From: Olly Mayhew [REDACTED]
Sent: 04 November 2020 10:24
To: Nicola Moore; Amber Willard
Subject: Re: Further information - Y/122/20/NMA
Attachments: OM010_NMA_04.11.2020.pdf

From: Olly Mayhew <[REDACTED]>
Sent: 02 November 2020 09:43
To: Planning <[REDACTED]> Nicola Moore <[REDACTED]>; Amber Willard
<[REDACTED]>
Subject: Further information - Y/122/20/NMA

The original application for the single storey side extension was approved some time ago and this NMA relates only to the side extension.

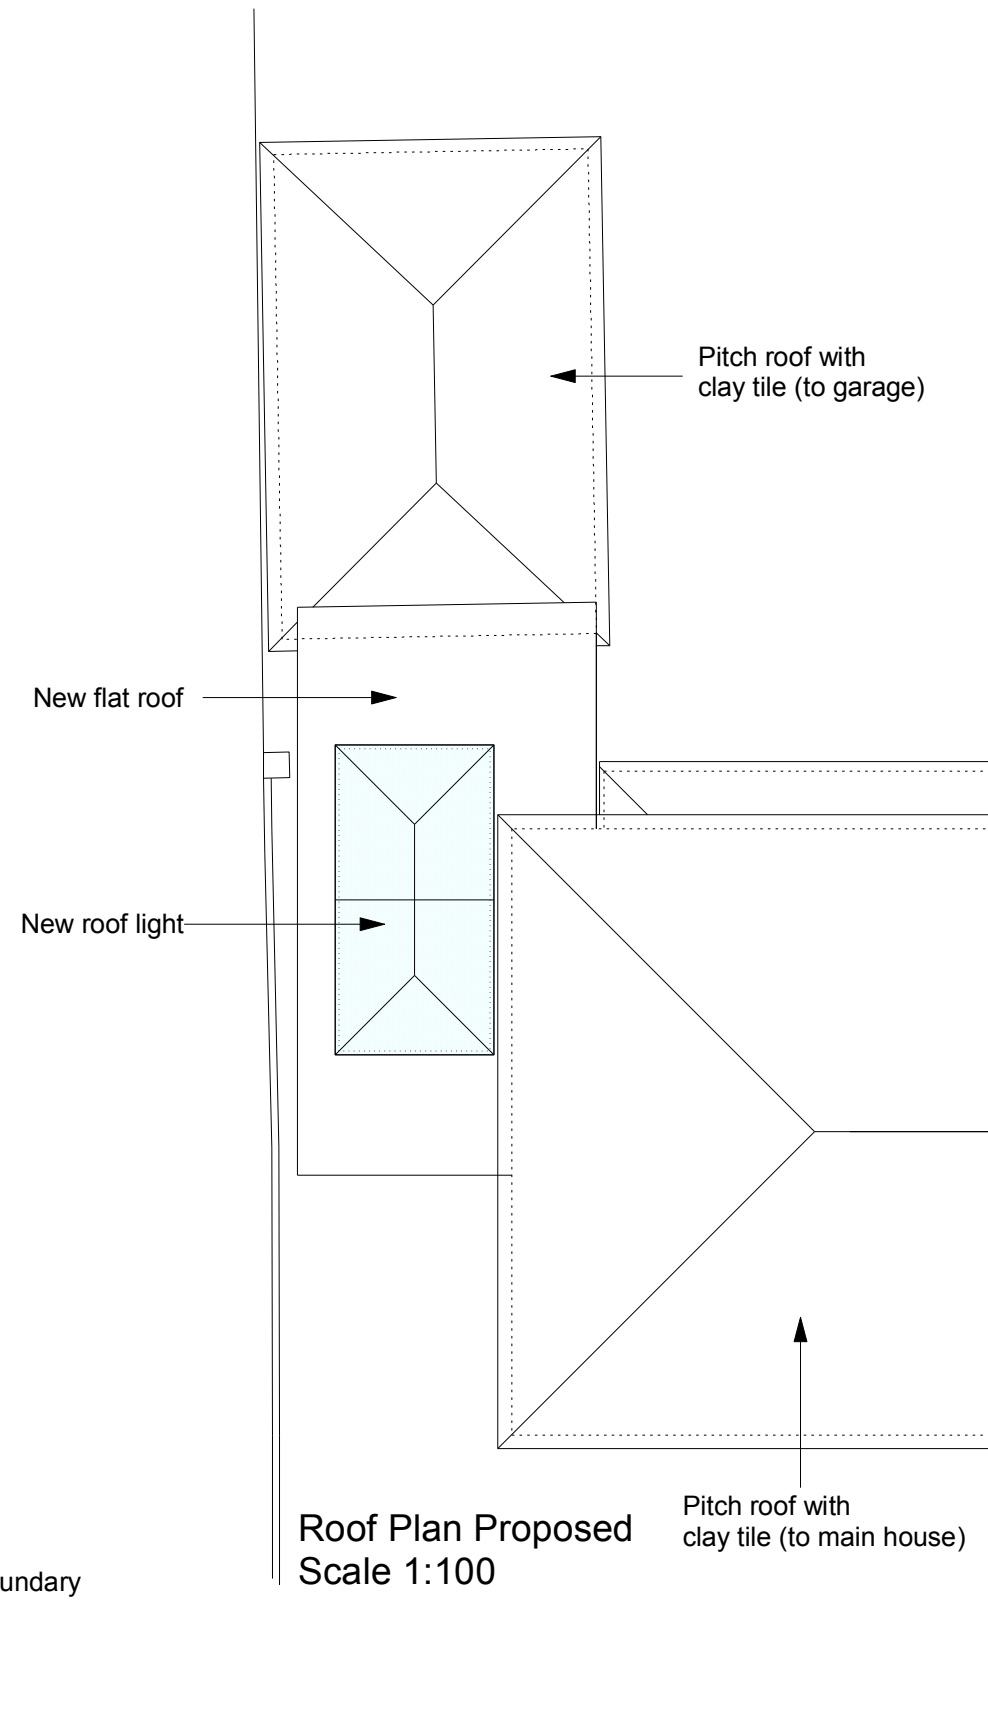
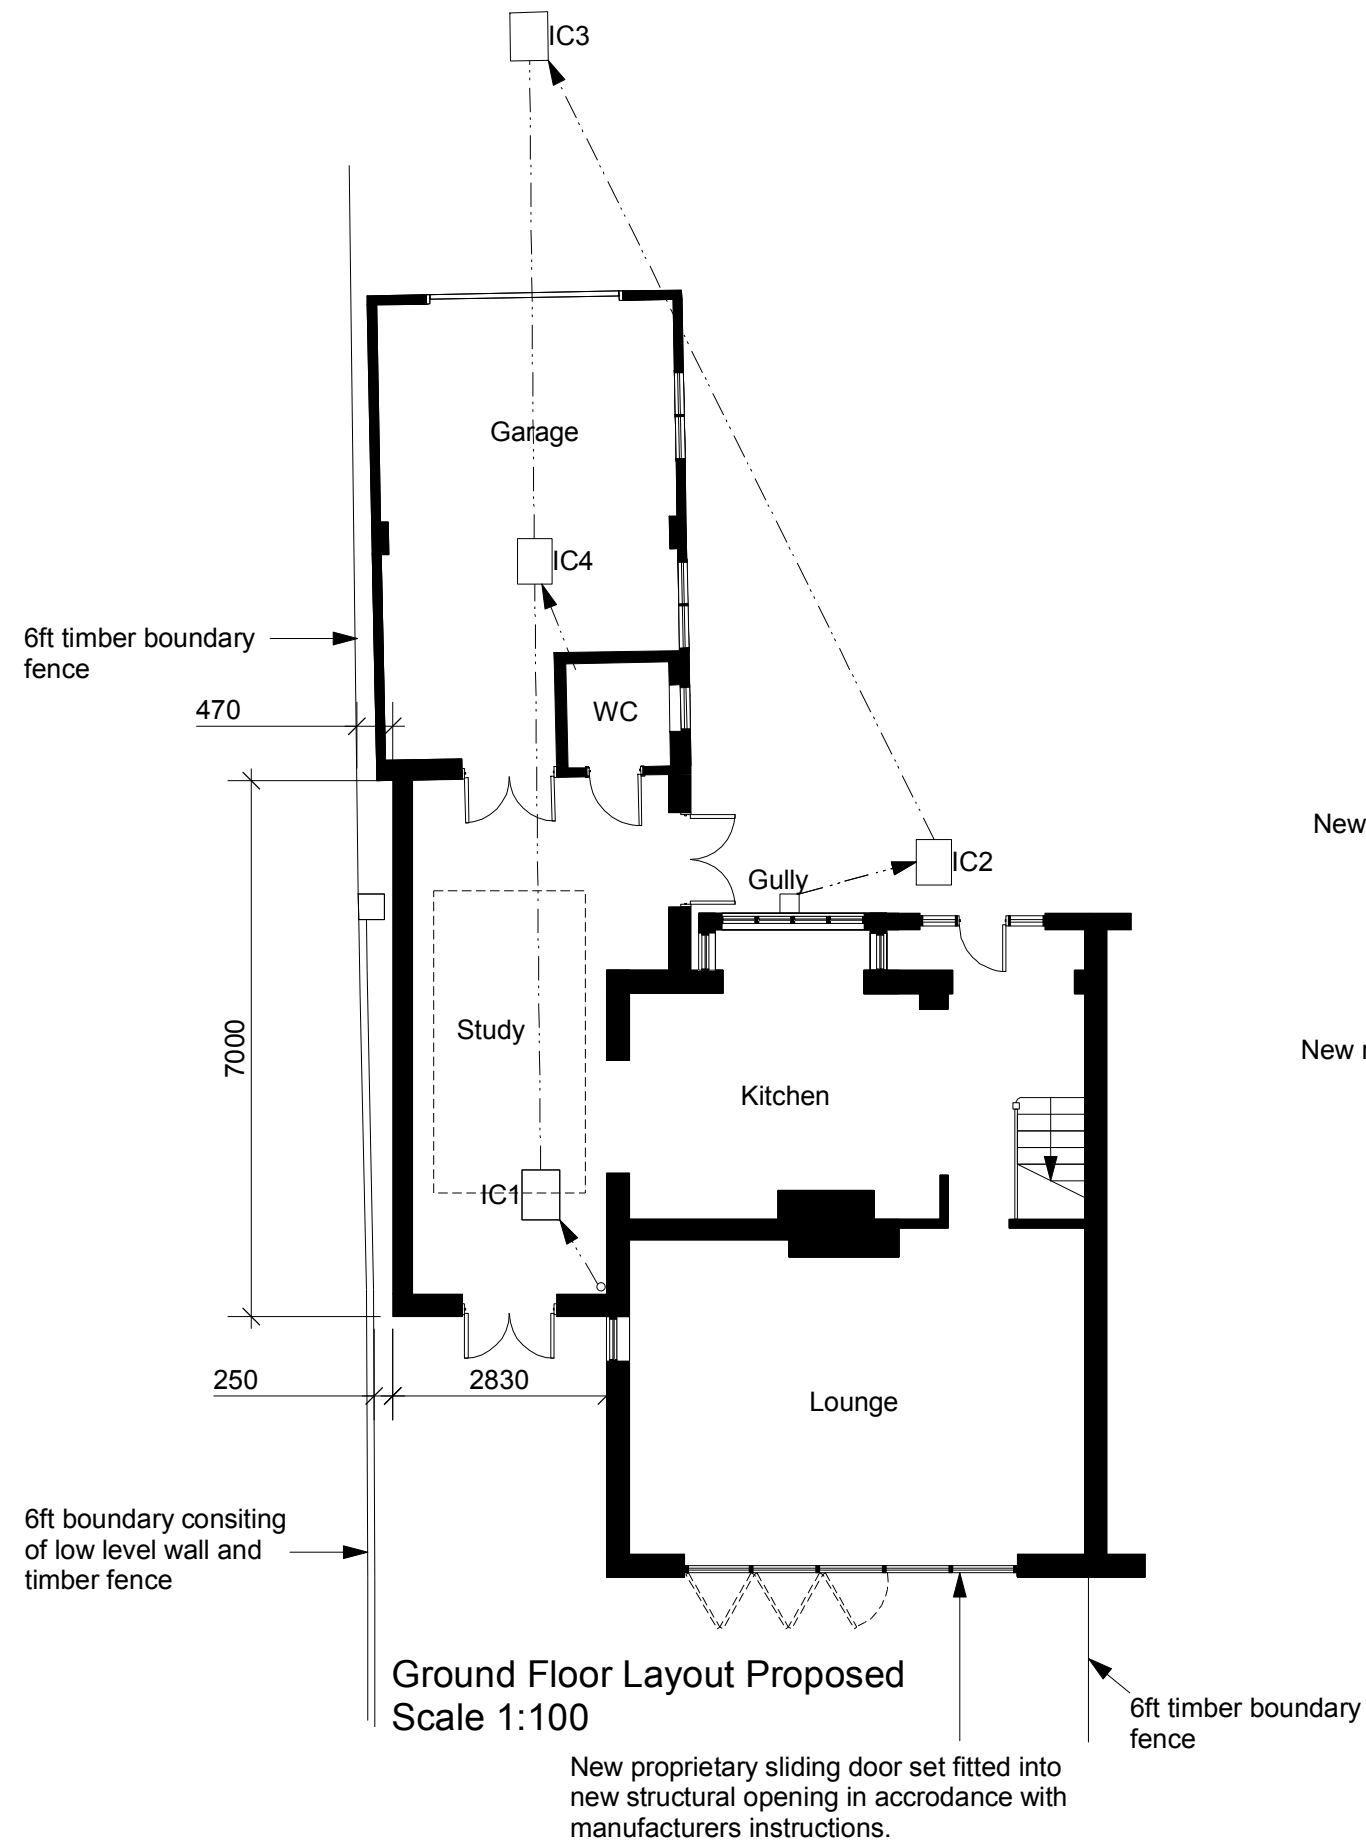
I have checked the Revised Extension plan (OM005 Rev B) and this does not appear to scale correctly as the new patio door at the front (East elevation) measures 0.66m at 1:100 but on Side Elevation plan (OM004 Rev B) it is 1.12m at 1:100.

Also, the Revised Extension plan is titled and numbered the same as the approved drawing (OM005 Rev B). Please amend accordingly to ensure the plans are clear when uploaded on to our website.

I have attached another document where I have updated the drawing number to OM010 and I hope this is satisfactory for you to now consider these minor alterations to the approved plans.

- Move the front (East elevation) wall and patio door back to be inline with the main west elevation of the house. The flat roof will not be altered in size to give a covered entrance porch.
- Change the single, large roof lantern to two smaller pano roof skylights.
- Brick up the garage window on the south elevation as we no longer require a new door to the garage.
- Disregard the extension into the garage for a w/c at this time.
